RE: MARNA LYNN TOWNHOMES (C-12/D3B3)
Engineers Certification for Release of Financial Guaranty
Engineers Stamp dated 02/03/2006
Engineers Certification dated 09/01/2006

Re: Marna Lynn Townhomes Grading and Drainage Plan
Engineer's Stamp dated 2-3-06 (C12/D3B3)

RE: GRADING & DRAINAGE PLAN FOR ALBUQ WEST PET RESORT (C-12/D3B3)
RECEIVED APRIL 3, 1996 FOR S DEV PLAN, FINAL PLAT & BUILDING PERMIT
ENGINEER'S STAMP DATED 02-22-96

GRADING & DRAINAGE
PLAN

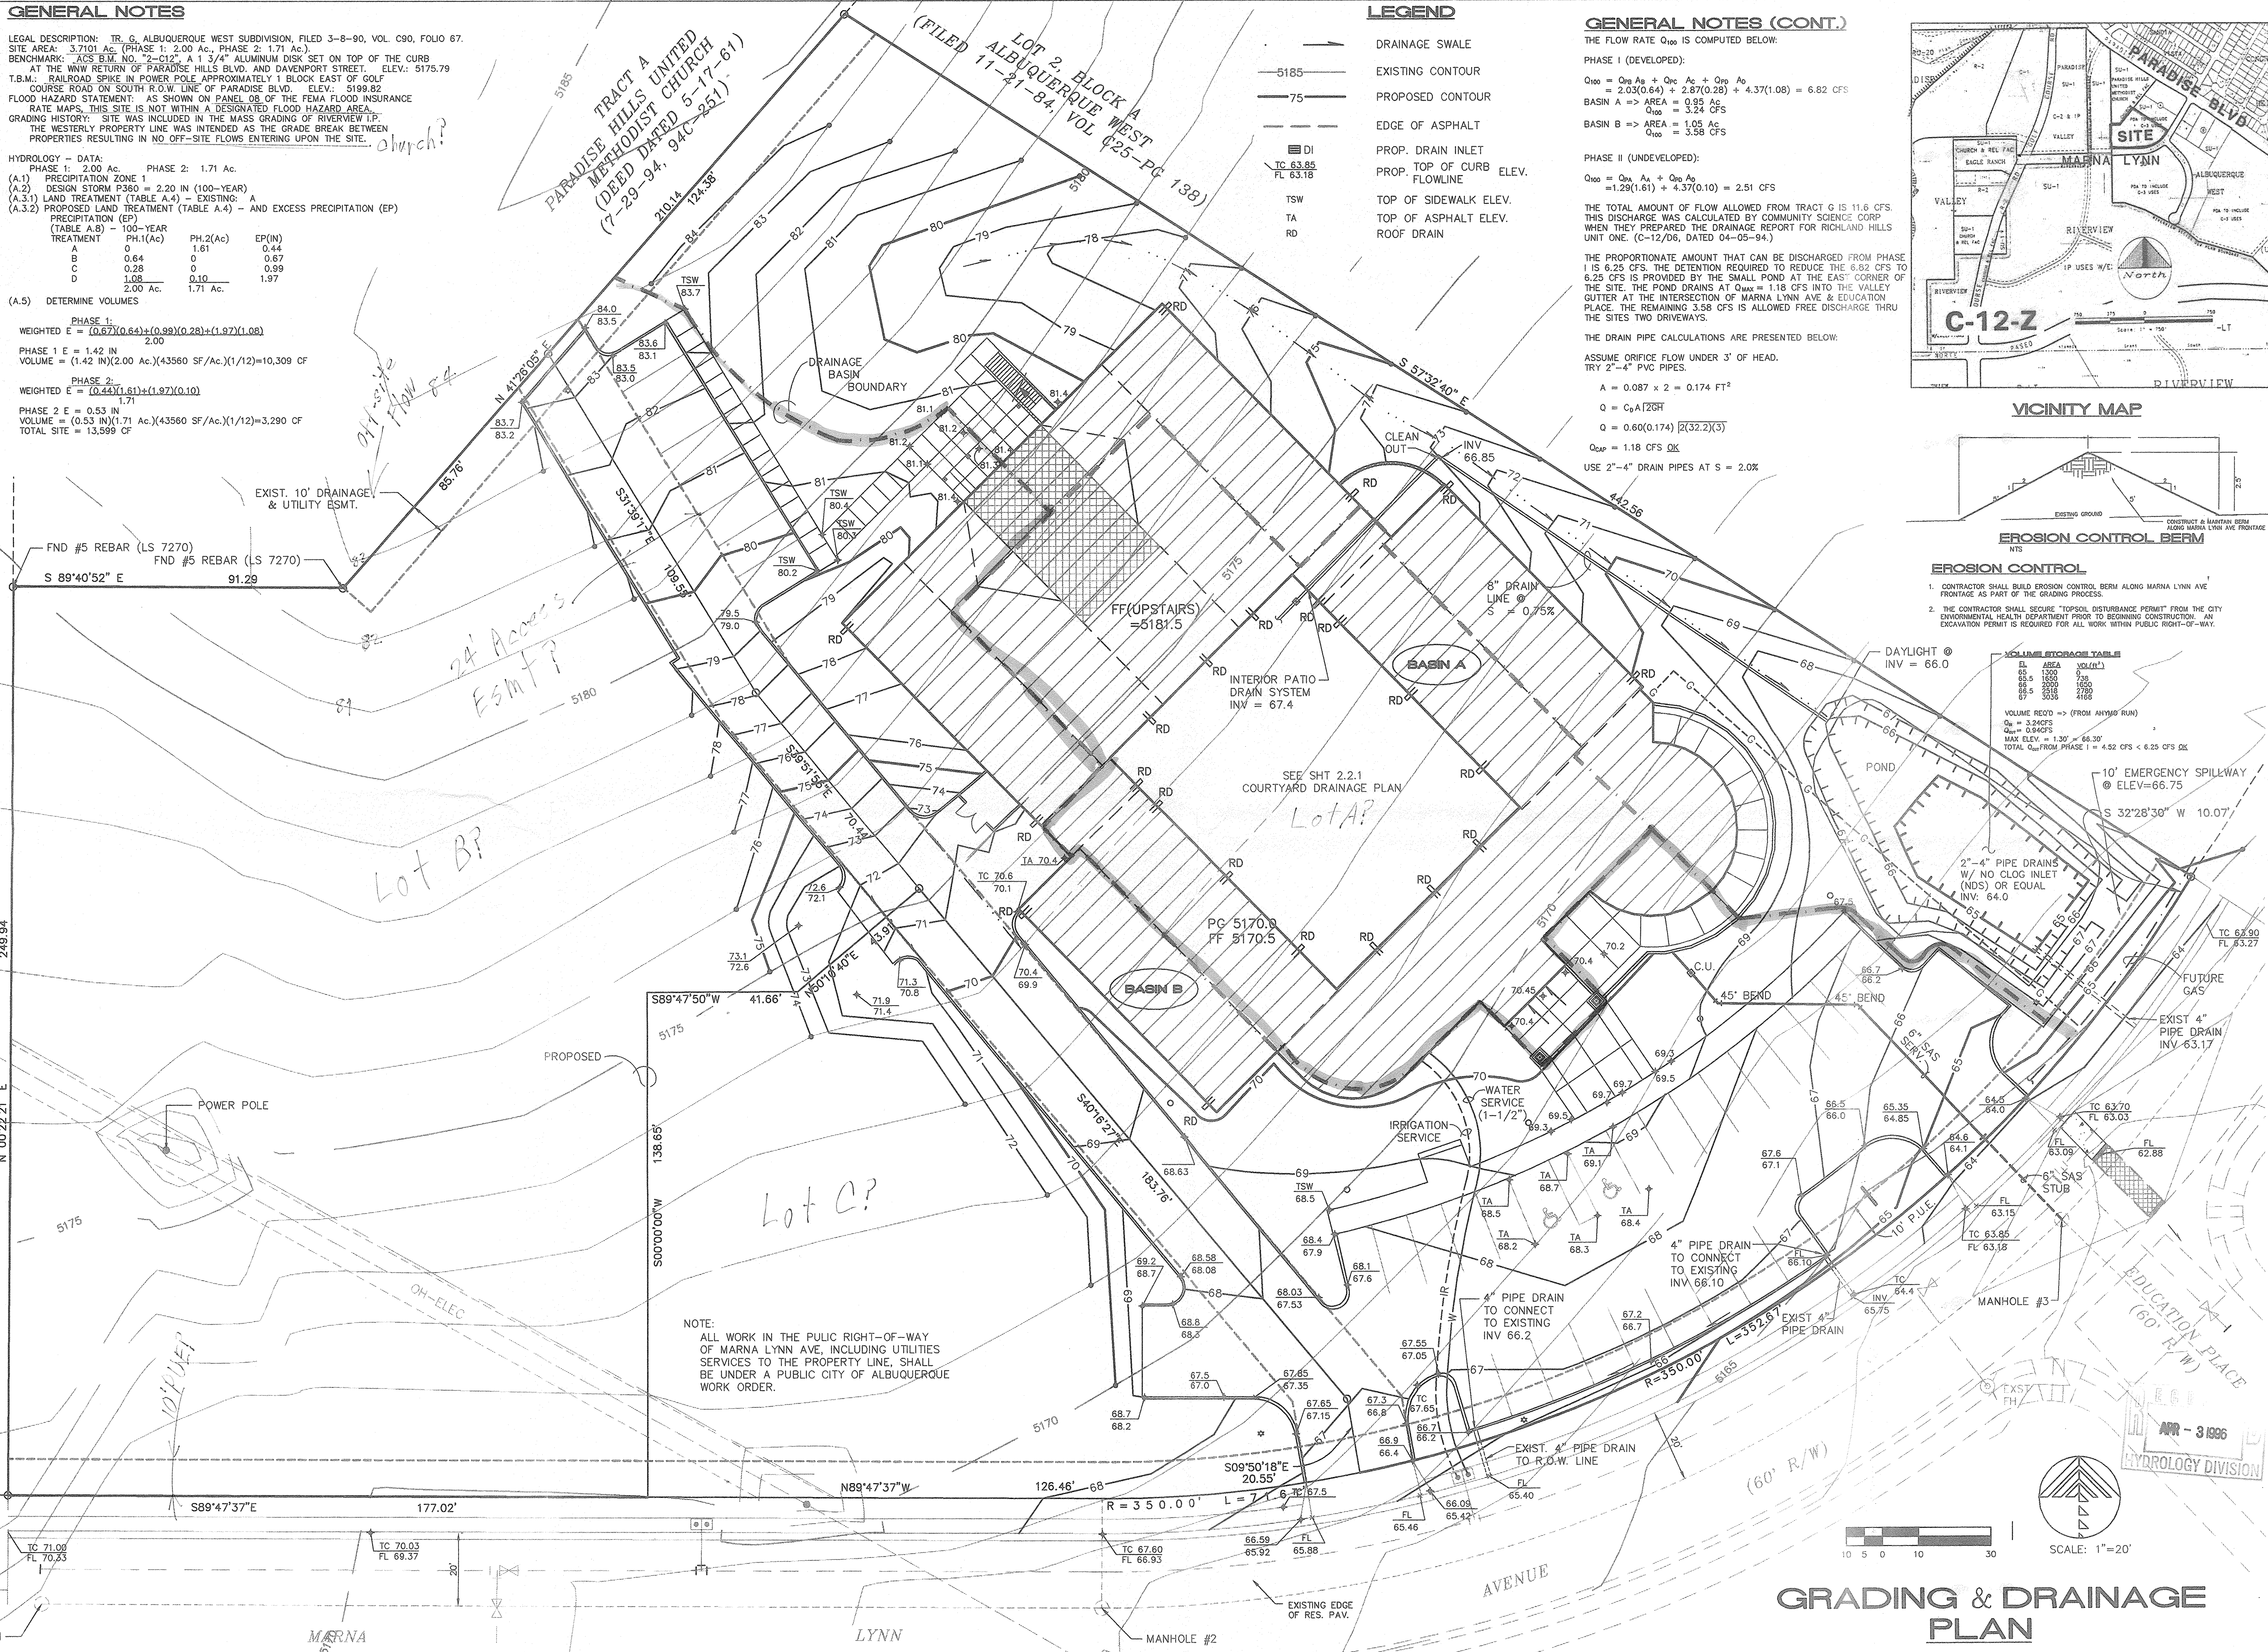
The following comments must be addressed before the Grading & Drainage Plan will be accepted for Final Plat: It appears that off site flow from the Church enters Phase 2. Address the impact on the site. Label each of the three lots and all easements. Identify the allowable discharge for each lot.
